4 Harefield Road
Middleton on Sea
Bognor Regis
PO22 6EB

M/7/26/HH

I am writing on behalf of the Committee of the Harefield Estate Association to strongly object to this application.

Proposed Side and First Floor Extension
Plans and Elevations
Planning

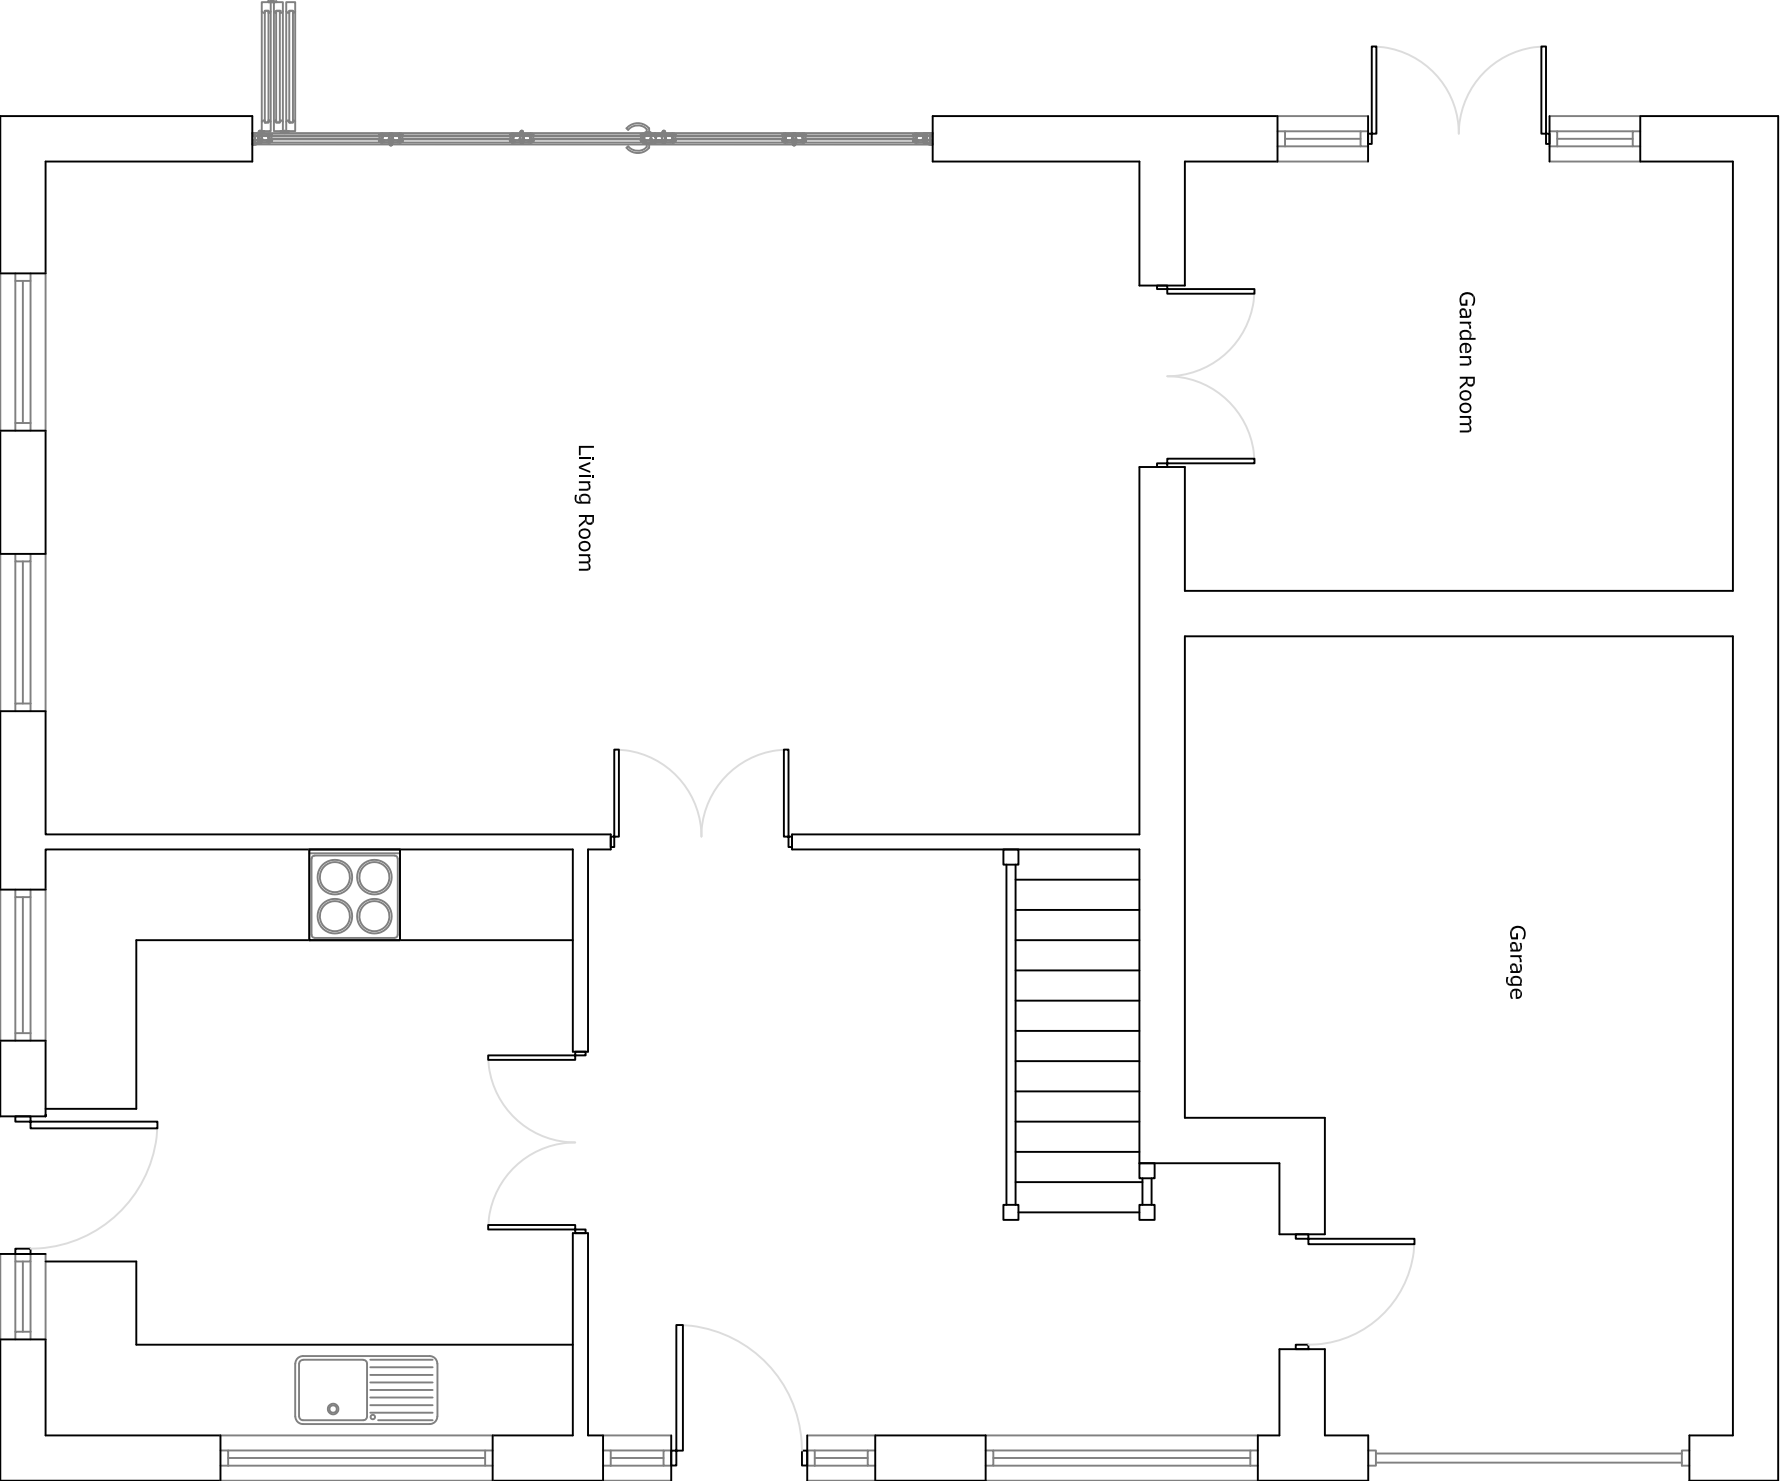
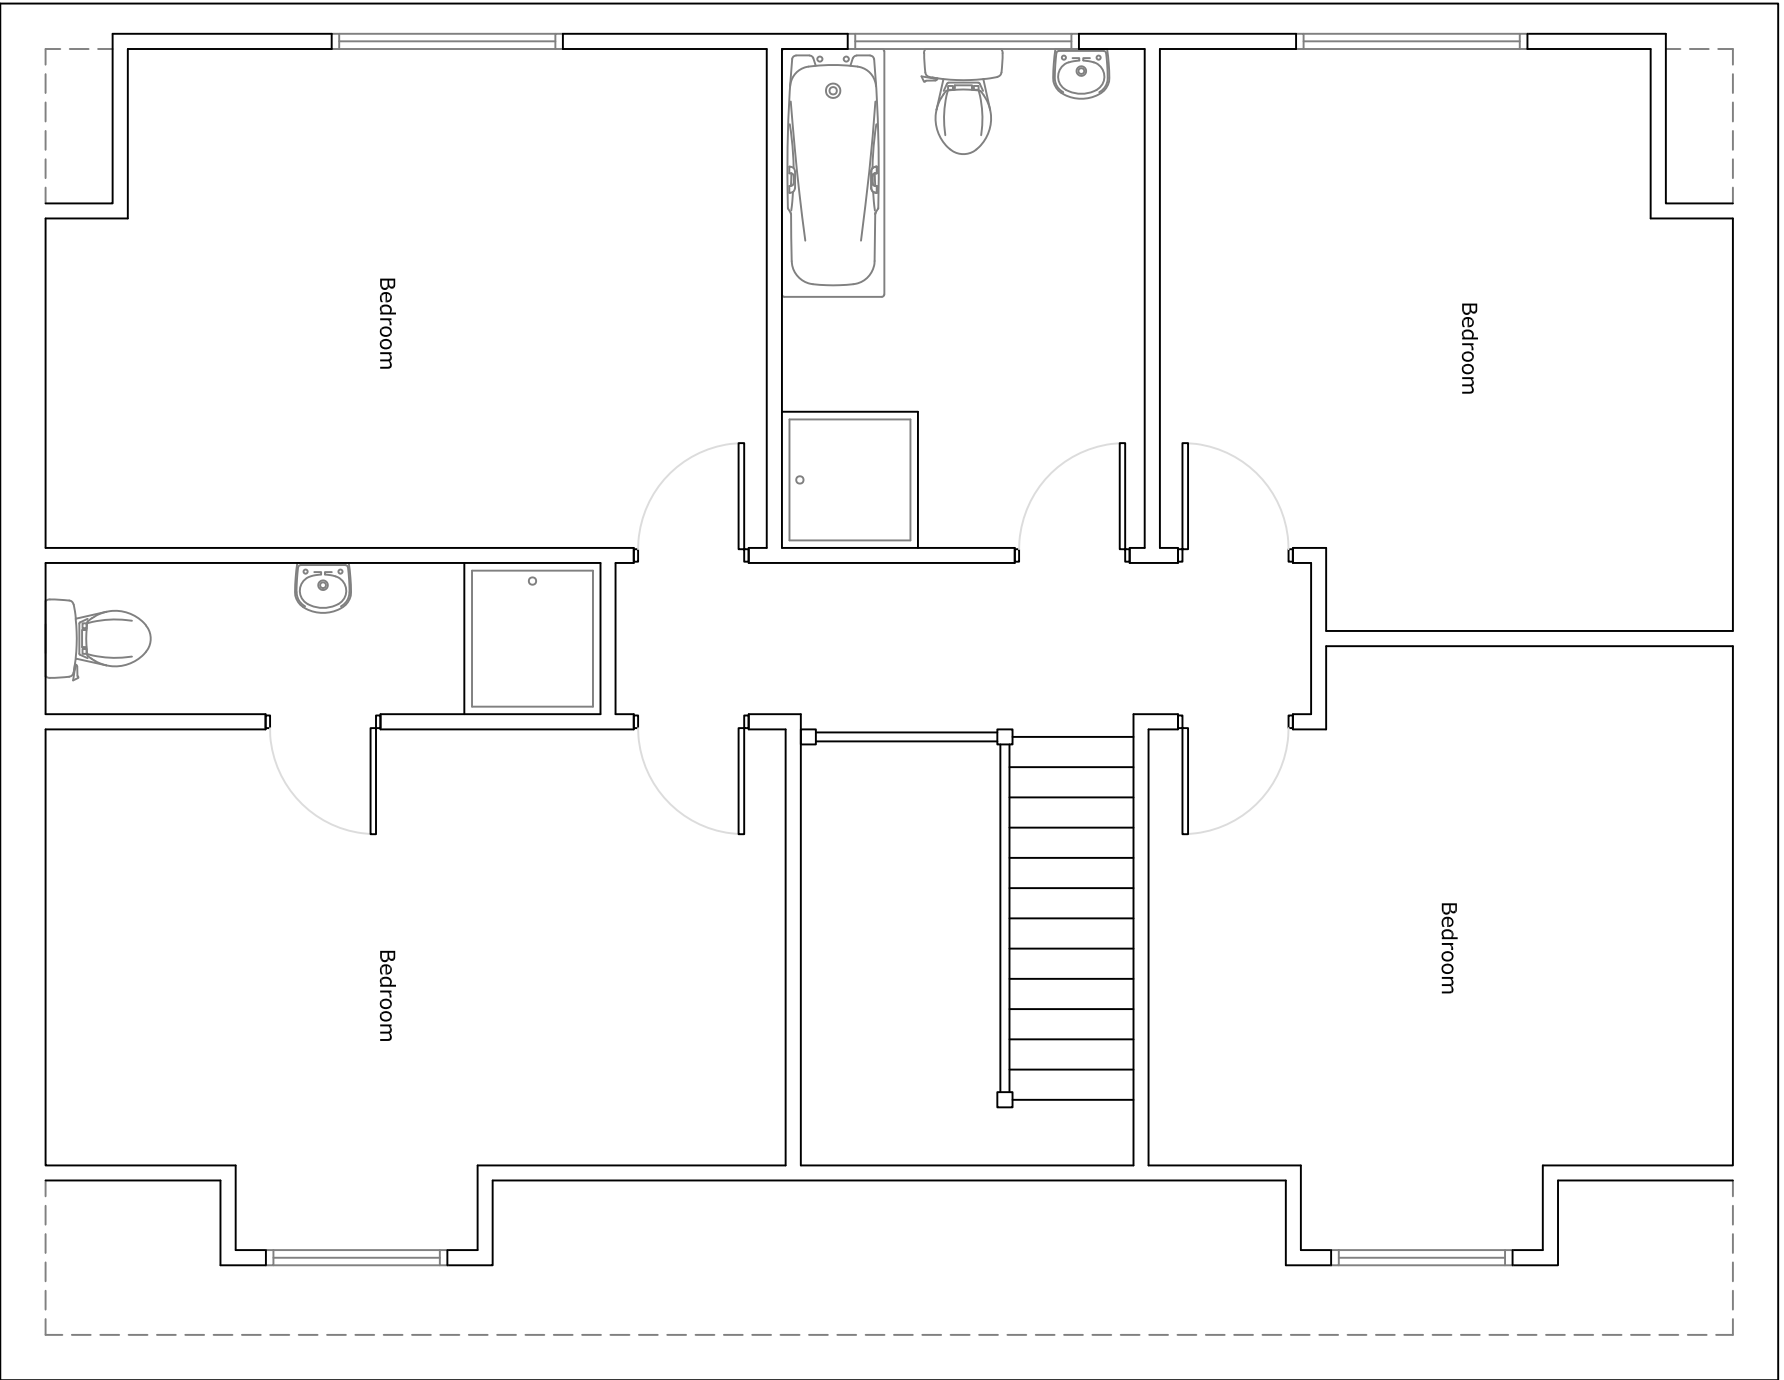
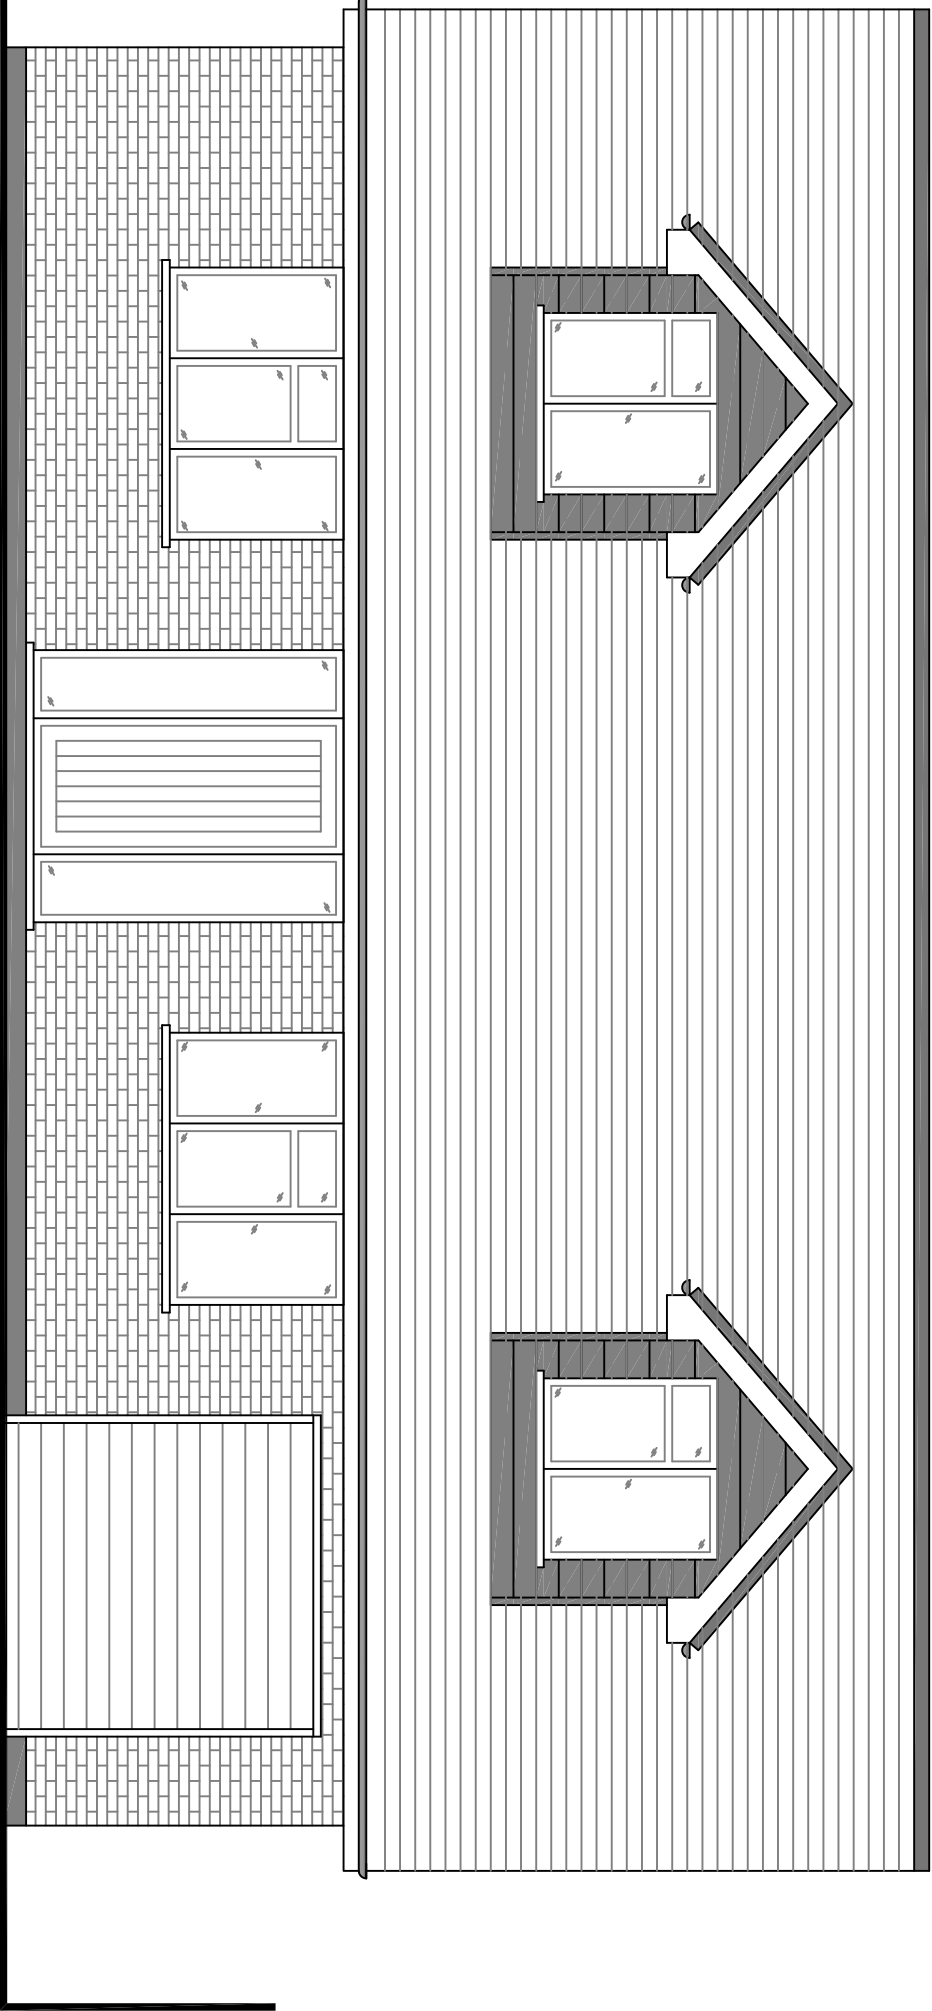
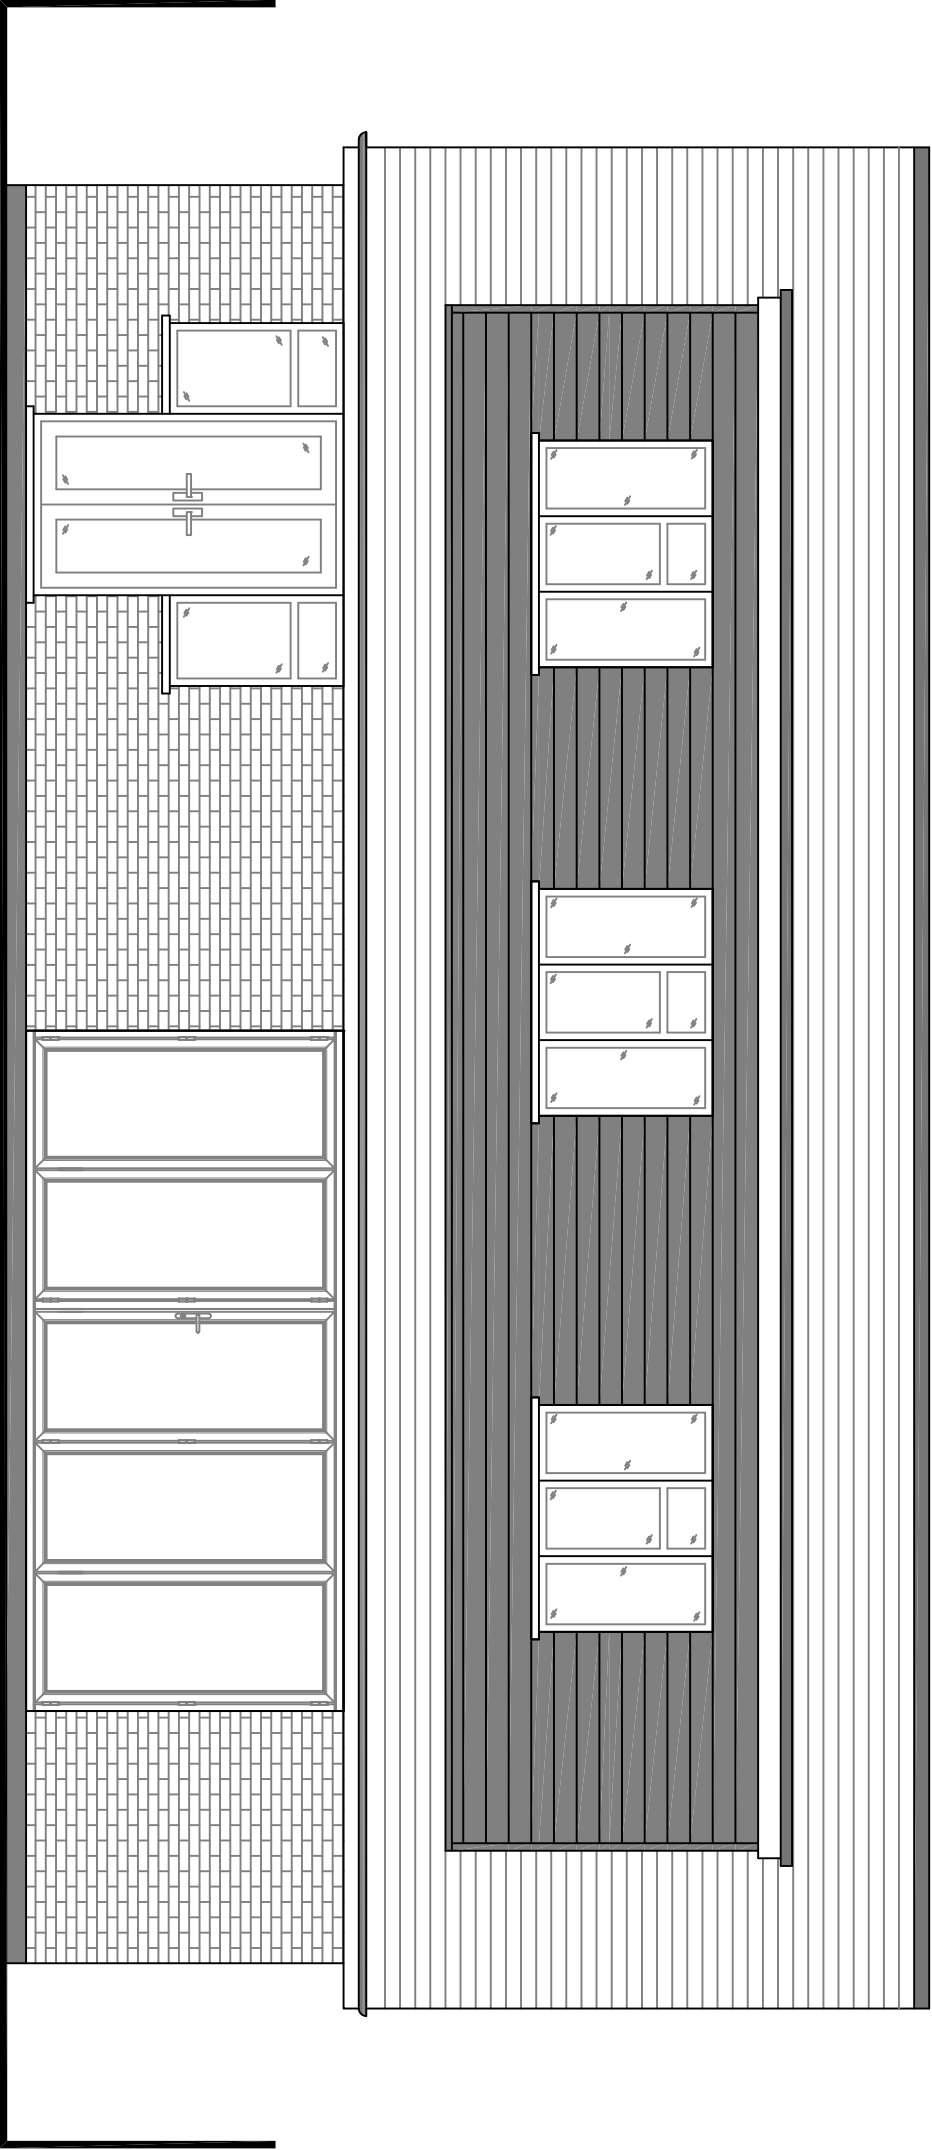
However, the plans propose an increase in the roof area, yet provide no evidence in support of the statement that the drainage is sufficient. No monitoring of ground water data has been supplied in support of this application. Nor has there been any infiltration testing as far as we are aware.

Finally the proposed design is in conflict with both the Arun design guide, and with the Middleton

“Alterations to the roof profile should not detract from the character and appearance of the dwelling or wider area in any case. This can be achieved through smaller scale dormer windows with pitched roofs which, when used in combination, tend to be more successful than single, large flat-roofed box-shaped dormers.”
